Matthew Rosel - Submission Details for Yun Tong (object)

Submission for Job: #5878 SSD 5878-2013 Sydney International Convention, Exhibition and Entertainment Centre
 Precinct - Mixed use Development in the Southern Haymarket Precinct (Concept Proposal)
https://majorprojects.affinitylive.com?action=view_job&id=5878

EIS Errors

Group submission relating to application SSD 5878

Figure 44 – Site Access and Parking

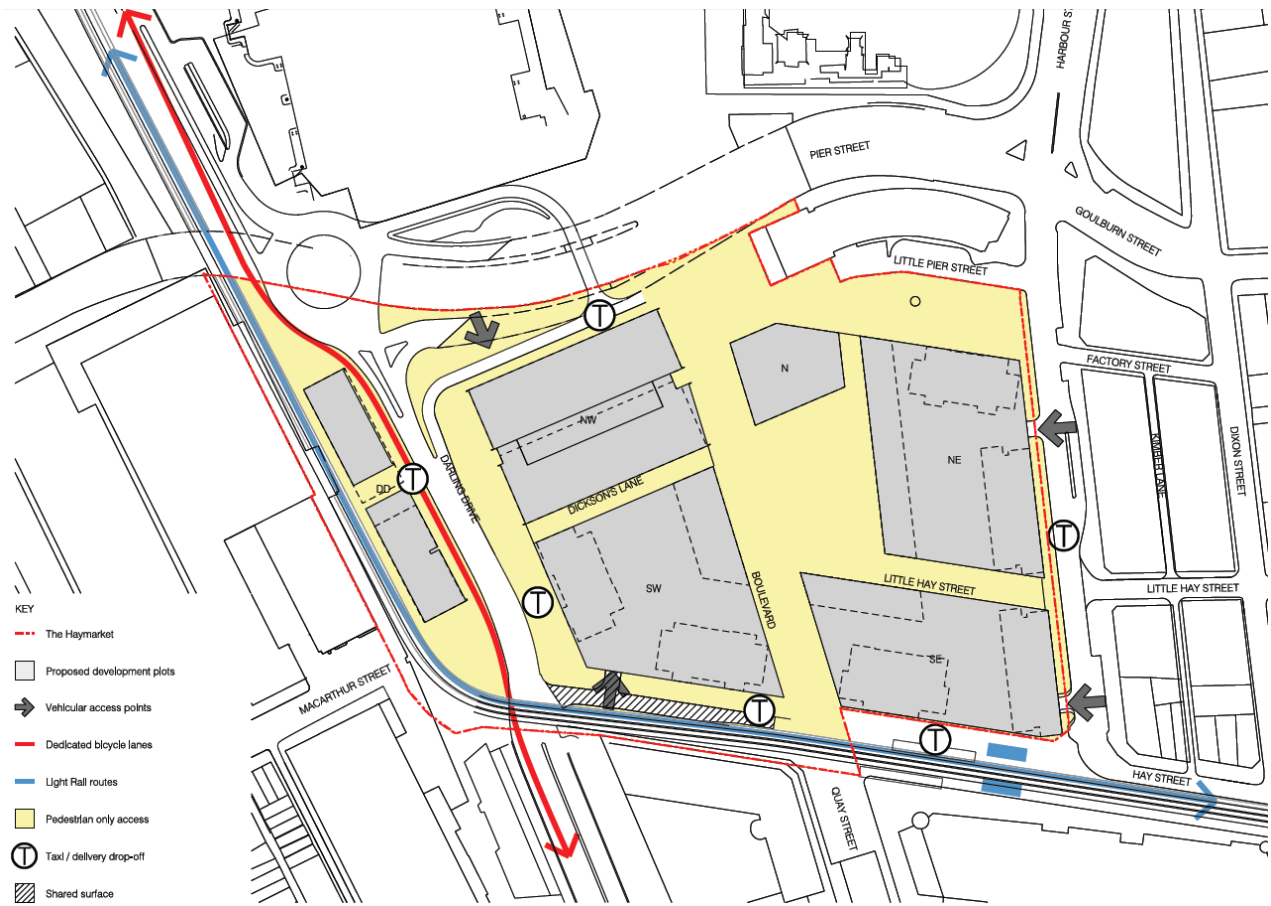
4. **The traffic studies do not include one of the three exit/entry points to Darling Drive, that being Ultimo Rd, the key to traffic movement for the PPP and the PDA.**

One of those is at Ultimo Rd, where the study states that 30% of the traffic flow to and from Darling Drive will be via Ultimo Road (section 7.1.1). Yet amazingly no traffic studies are done on this intersection !

Multiple references are made to traffic movement from Darling Drive into Quay St. **There is no such intersection.** There is a remnant of Quay St which is the entry point to the existing SEC car park, which is referred to separately in the study as the new SW carpark entry/Hay Street.

The study has not factored in the traffic exiting the Haymarket Precinct from Harbour Street that will need to cross to Darling Drive via Pier St, to get to Ultimo Rd if they want to access Broadway to go west or east without going through the City. Similarly, traffic exiting the SW blocks will need to go via Darling Drive and enter Ultimo Rd.

Figure 49 – Compliance of illustrative typical floor layouts with cross ventilation requirements

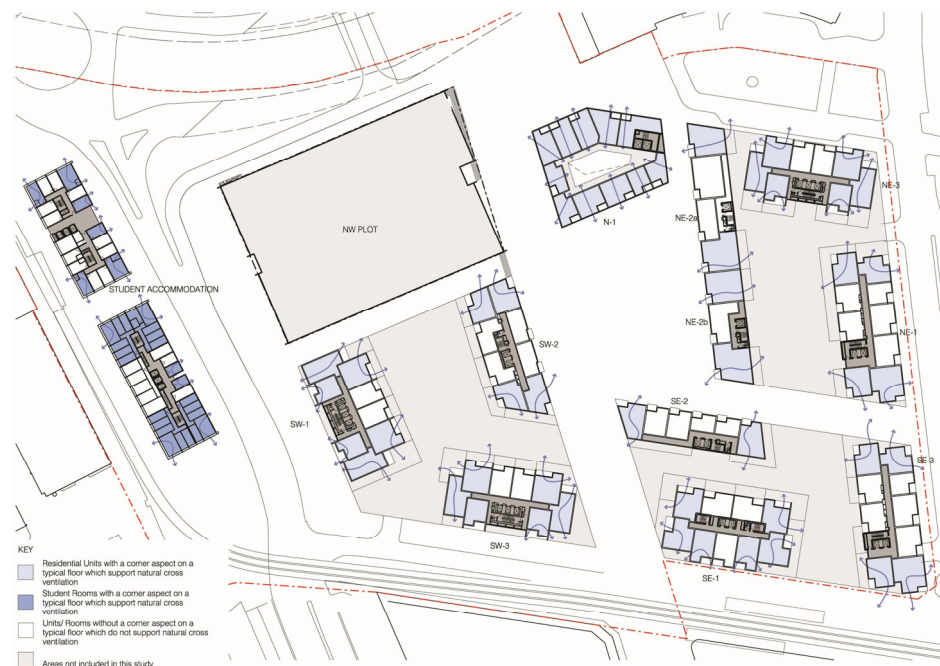
Each of the nine buildings has a proposed depth greater than the maximum 18 metres specified in the Residential Flat Design Code, and the developer fails to address the specific criteria in the Code under which the maximum may be exceeded.
